From: Sarah Burrow <Sarah.Burrow@arun.gov.uk>
Sent: 22 January 2021 16:38
To: Maria Tomalova <Maria.Tomalova@arun.gov.uk>
Cc: Planning.Responses <Planning.Responses@arun.gov.uk>; [REDACTED]
Subject: RE: Y/142/20/DOC

Engineers Comments Regarding Surface Water Drainage

At this stage it is not possible to recommend that conditions 10 or 11 imposed under Y/121/19/PL are discharged. I have the following comments that require addressing before I can recommend discharging the conditions:

Soakaway Test No. SA203 - Test 2
Contract: Yapton
Contract No. J20-043

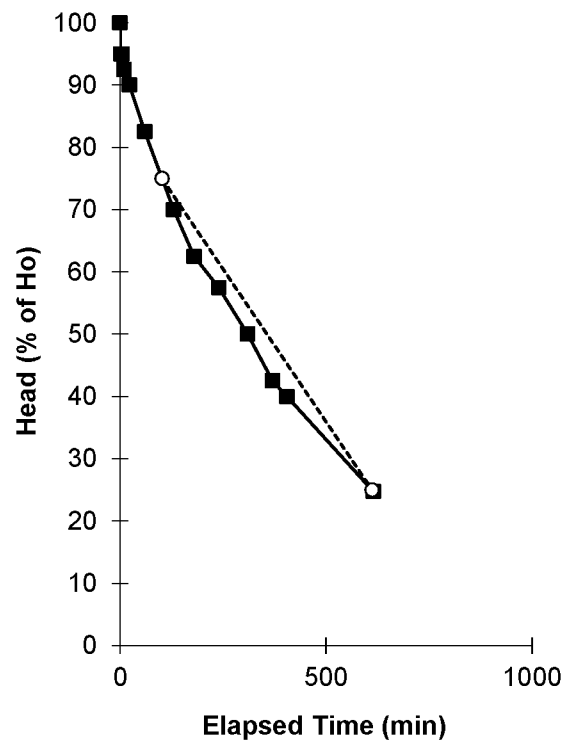
On the basis of the above, it is recommend that further infiltration testing is completed now, to capture the infiltration rate in the correct period. This can be just one test pit in the location with the slowest rate (SA203 – 2.97×10^{-6} m/s) results can then be compared to the autumn testing. Please ensure that the testing is no deeper than 0.6mbgl, assuming groundwater is evidenced below this level.

3. The calculations do not use the slowest infiltration rate for the site of 2.97×10^{-6} m/s (SA203). These will need to be adjusted irrespective of the outcome of points 2 and 3.
4. Please confirm that the calculations include the access road for the impermeable area. They state 'car park + driveway + roofs', the same is stated for the permeable car parking areas. Please supply an impermeable area plan as per the Drainage Checklist.
